Tel: 01903 737756
Email: planning@arun.gov.uk
www.arun.gov.uk/planning
Please ask for: Ms Iqraa Malik
Email: iqraa.malik@terraquest.co.uk
Telephone: 0121 234 1390
Our Ref: Y/1/26/HH
Your Ref:
Date: 13th January 2026

Application for Planning Permission for Works or Extension to a Dwelling

Development: First floor extension
Location: 34 Downview Close Yapton BN18 0LD

LOCATION PLAN
SCALE 1:2500 (A-A3)

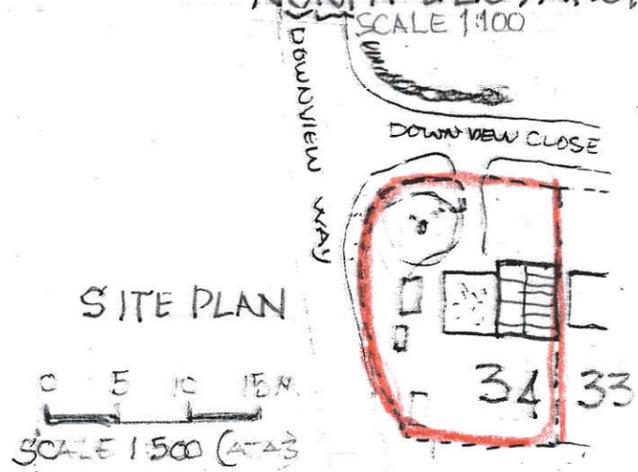
The location plan requires a solid red outline around the site boundary, please review and amend.

G. GRAHAM - PROPOSED ~ 1261/02 July 2005

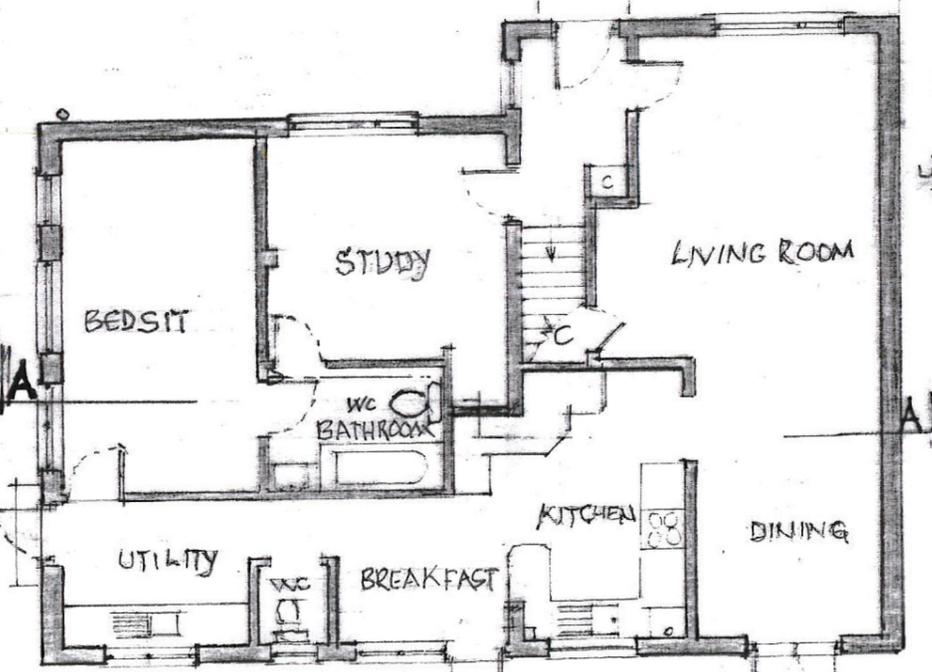
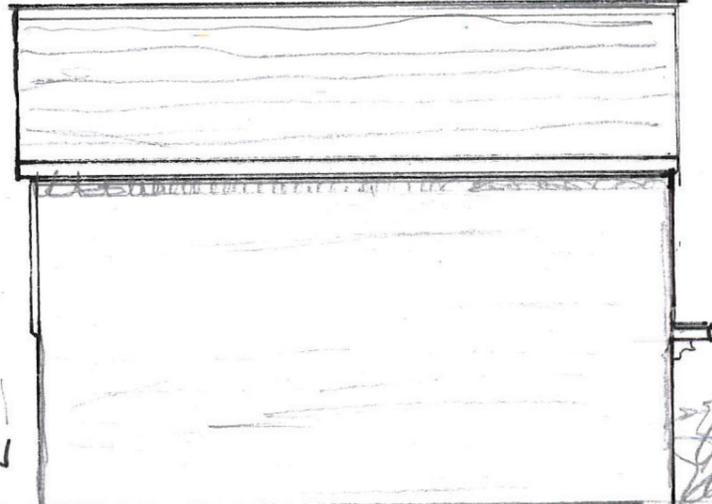
The proposed south elevation is inconsistent with the proposed first floor plan, please review and amend.
